Proposed Housing Development  
Pear Tree Farm, Church Street,  
Brierley, Barnsley, S72 9JR.

Designer's Response Report to RSA Stage One Audit.

This Designer's Response Report addresses the issues raised within the Stage 1 Road Safety Audit (RSA1) dated 5th June 2025, conducted for the proposed Section 278 highway works to support a 10-dwelling residential development at Pear Tree Farm, Church Street, Brierley, Barnsley.

drawing  
**PROPOSED REFUGE VEHICLE TACKING AND ACCESS DETAILS**

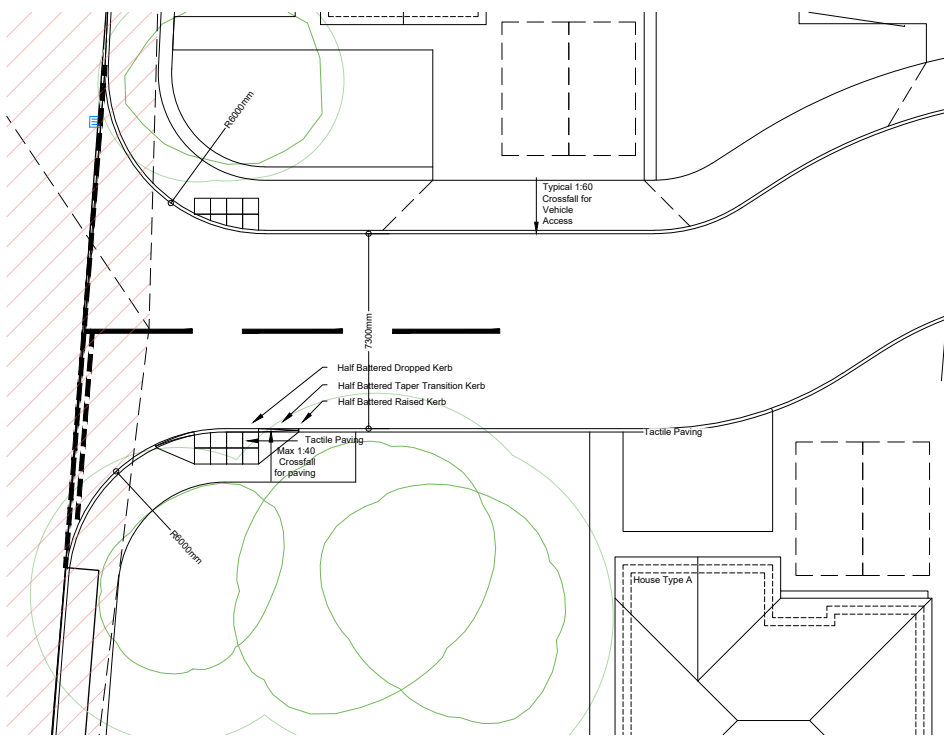
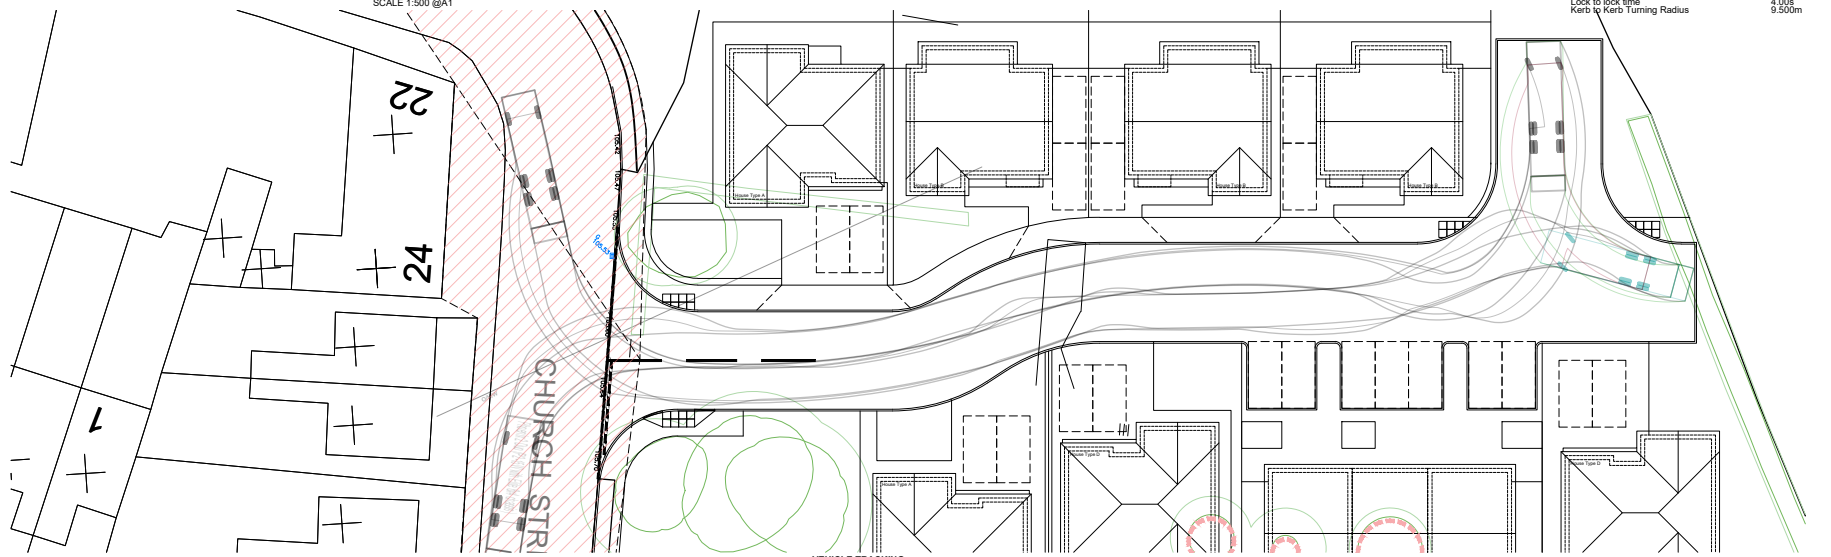
### Problem 3.1: Excessive Approach Speeds May Lead to Vehicle Conflict at Site Access

RSA Location: Proposed site access junction with Church Street, specifically the westbound approach where Church Street bends.

Summary of Problem: The RSA team observed that vehicles approaching from the west, negotiating the right-hand bend near the site, appeared to be travelling at speeds which may exceed what the proposed visibility splay can safely accommodate. There is concern that if actual speeds exceed the design assumption (30 mph), this could lead to increased risk of 'pull-out' type collisions, where vehicles turning out of the site are struck by through-traffic.

RSA Recommendation: Undertake a speed survey to verify actual approach speeds. If 85th percentile speeds are significantly above the 30 mph posted limit, then measures to reduce approach speeds should be considered, such as:

Speed Survey and Results Analysis: A 7-day Automated Traffic Count (ATC) was conducted on Church Street, approximately 50 metres west of the proposed access, to capture vehicle speeds and flow in both directions.

85th Percentile Speed: Recorded at 25.6 mph (7-day average)

Well within the 30-mph limit, and below the threshold that would justify a 62m visibility splay.

The proposed visibility splays from the new site access are as follows: 44 metres to the North, in the direction of the observed bend and 86 metres to the South, toward the town centre.

These distances were measured at a 2.4m x-distance set-back, in line with Manual for Streets (MfS) guidance.

The 44m splay to the North matches the requirement for 25mph – consistent with actual observed speeds. Conclusion from Design Review: The proposed visibility splays are safe and compliant with National Design Standards based on actual traffic speeds.
